Recommendation Report for Planning Permission for Works or Extension to a Dwelling

REF NO: FG/134/21/HH

LOCATION: 20 Onslow Drive
Ferring
BN12 5RS

PROPOSAL: Single storey rear extension

ARW Design	DRAWING TITLE: BLOCK PLAN & ROOF PLAN PROJECT: SINGLE STOREY REAR EXTENSION		LOCATION: 20, ONSLOW DRIVE, FERRING CLIENT: R & T. COLLINS		SCALE: AS NOTED @ paper size A3 DATE: JULY 2021		DRAWING NO: 6025/6
					DRAWN: ARW REVISION:

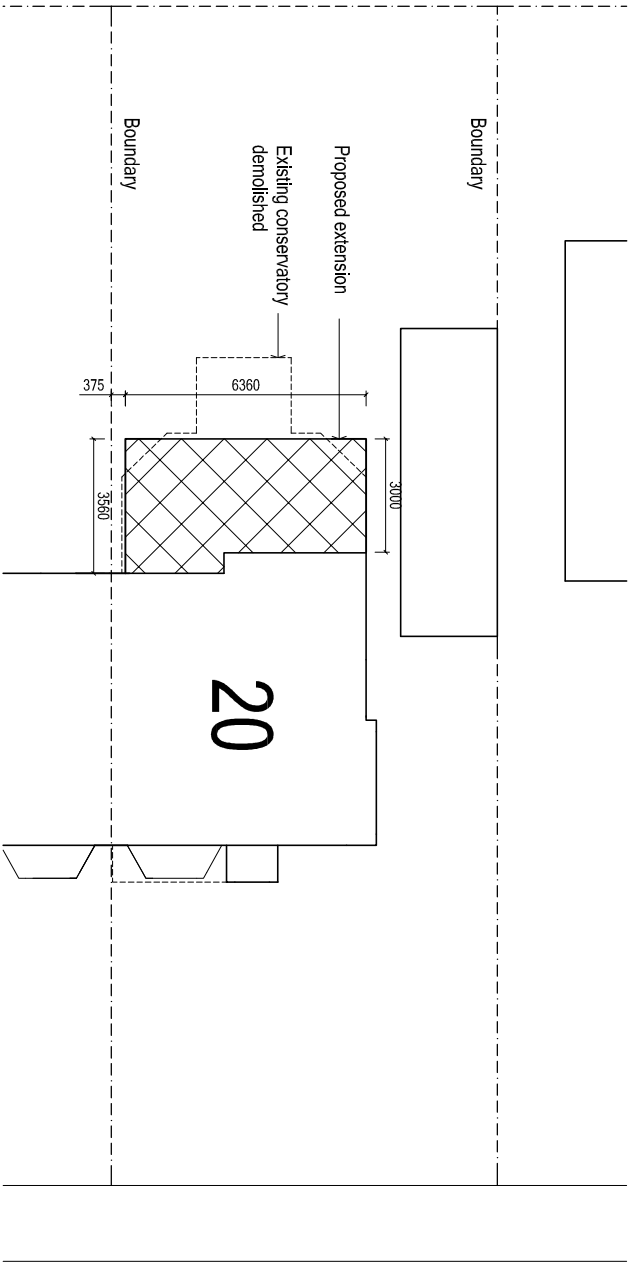
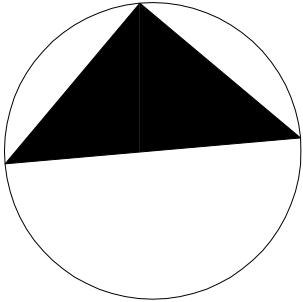
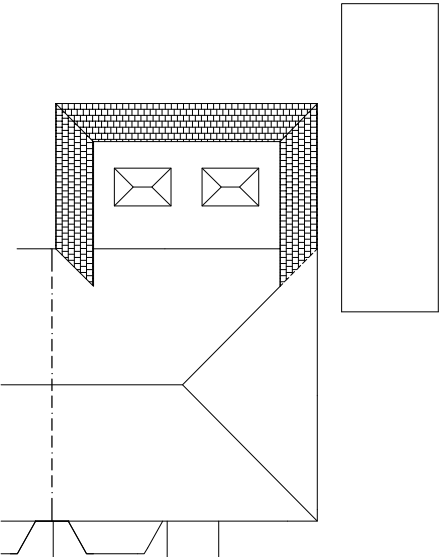
A 11m rear garden will be retained, this is over design guidance recommendations.

ARW Design	DRAWING TITLE: PROPOSED ELEVATIONS PROJECT: SINGLE STOREY REAR EXTENSION	LOCATION: 20, ONSLOW DRIVE, FERRING CLIENT: R & T. COLLINS	SCALE: AS NOTED @ paper size A3 DATE: JULY 2021	DRAWING NO: 6025/1 REVISION:
------------	---	---	--	---

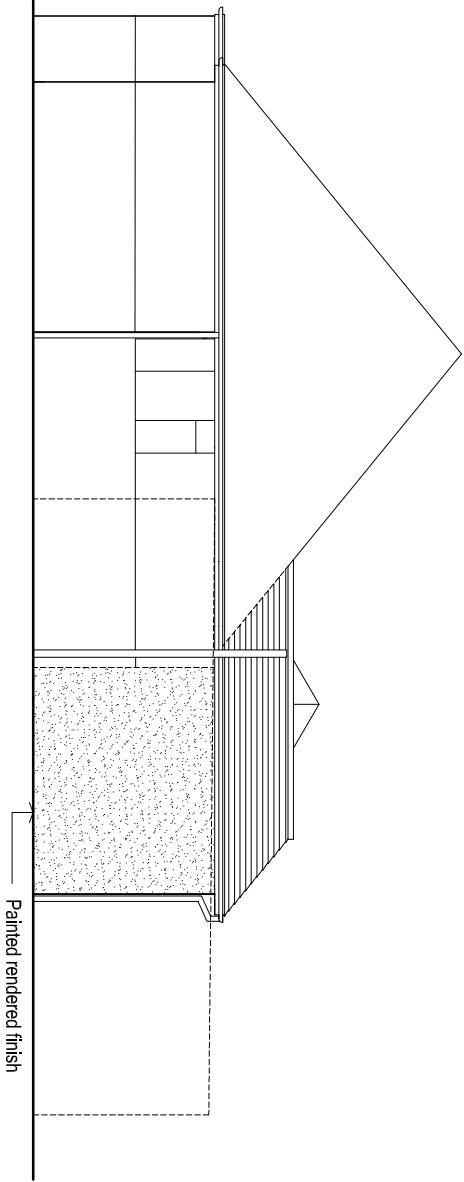
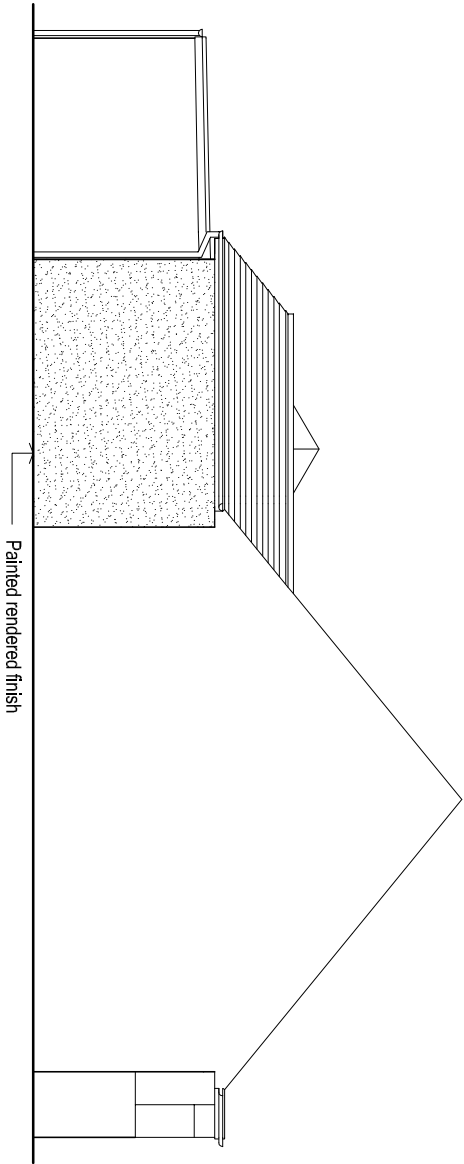
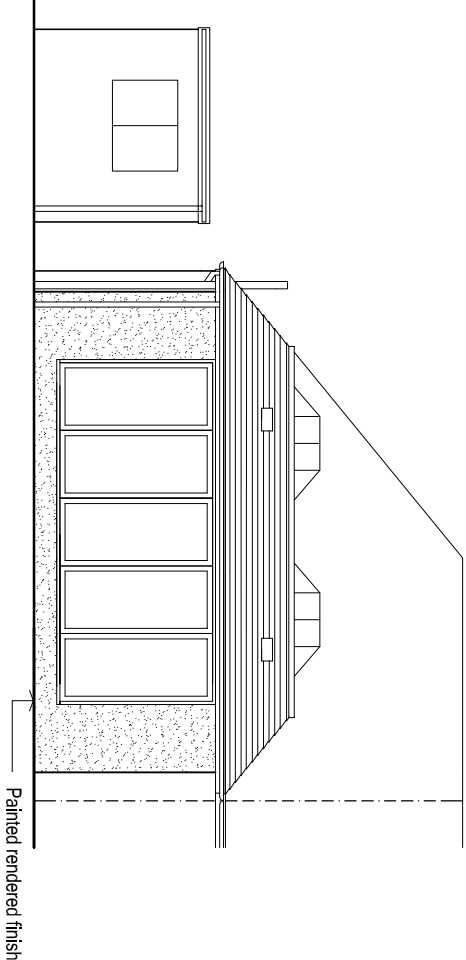
The extension is also thought to be well integrated with the host dwelling as it utilises materials which match those found on the existing building and the partially pitched roof is of the same pitch as existing, the eaves line is to be continuous. The extension is considered to be an attractive addition.

A set of bifold doors will achieve views over the rear garden and 2 roof lanterns will provide light from

ARW Design	DRAWING TITLE: PROPOSED FLOOR PLAN PROJECT: SINGLE STOREY REAR EXTENSION	LOCATION: 20, ONSLOW DRIVE, FERRING CLIENT: R & T. COLLINS	SCALE: AS NOTED @ paper size A3 DATE: JULY 2021	DRAWING NO: 6025/3
		DRAWN: ARW	REVISION:

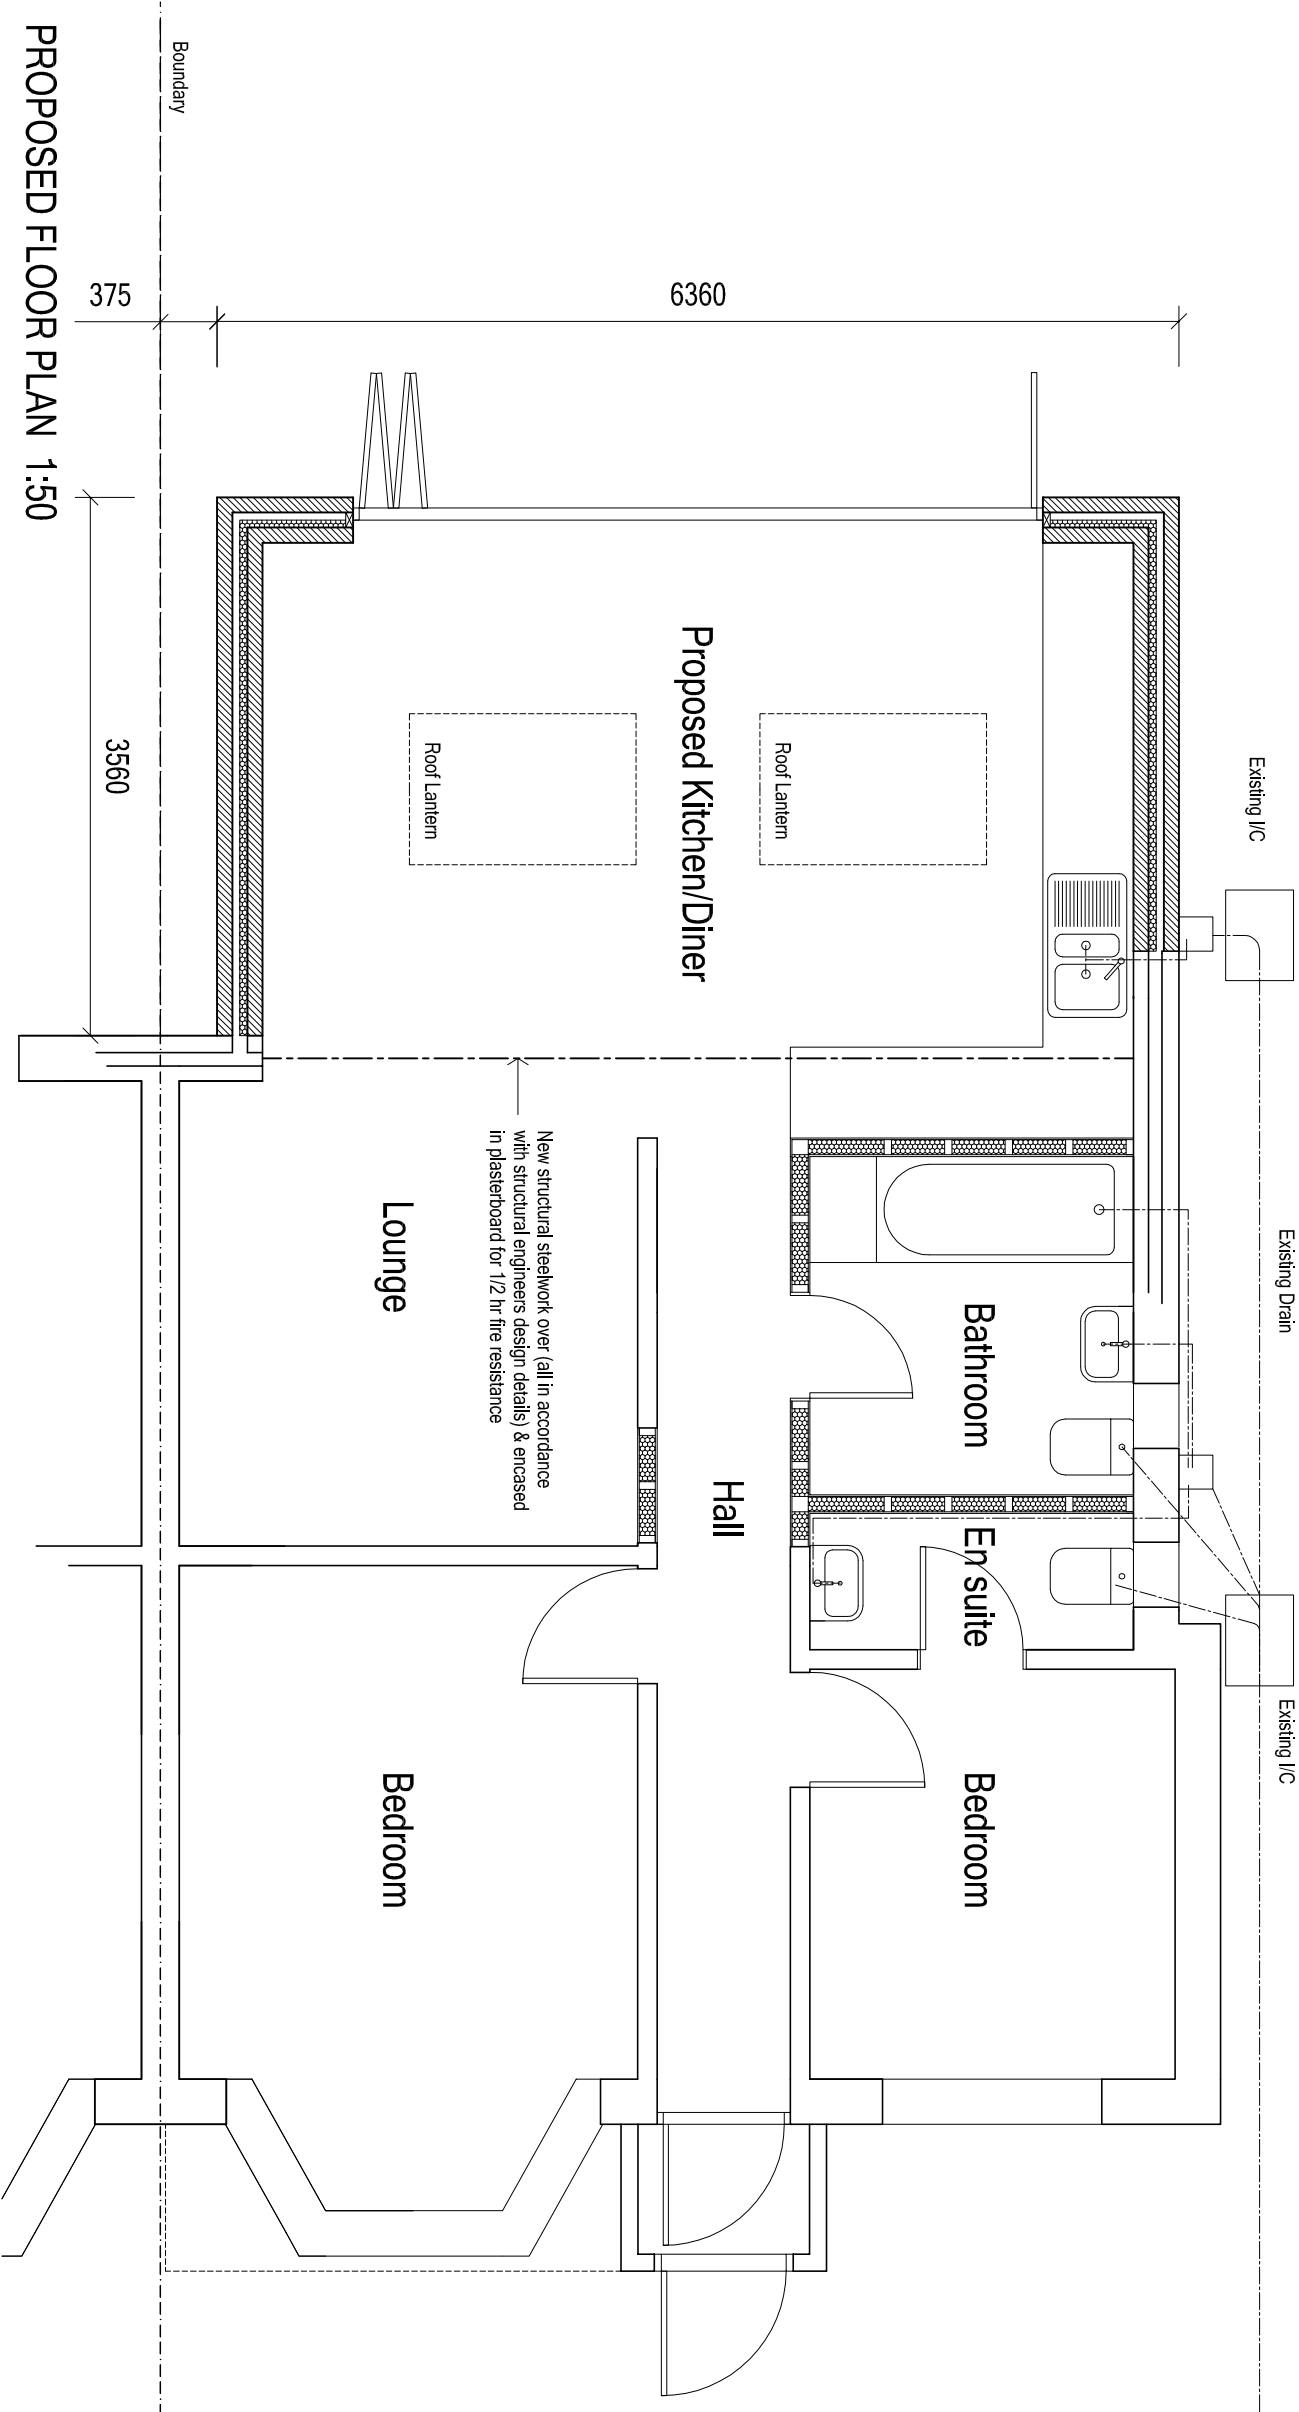
The proposal seeks to enlarge the habitable accommodation at ground floor level through the provision of a single storey rear extension. The extension is to be almost full width across the back of the house all bar 375mm gap between the extension and the boundary line with the attached neighbour to the West. The amount of habitable space provided is believed to be proportional to the dwelling.

A conservatory which has a similar footprint will be demolished as part of the works. The proposed extension is to be shorter in length than the existing structure; however, whereas the existing has chamfered corners the proposed is to be rectangular. The proposed structure will impede within the 45-degree line from the centre of the attached neighbours most easterly window. Due to the presence of an existing structure this is not seen as a reason to refuse this application.
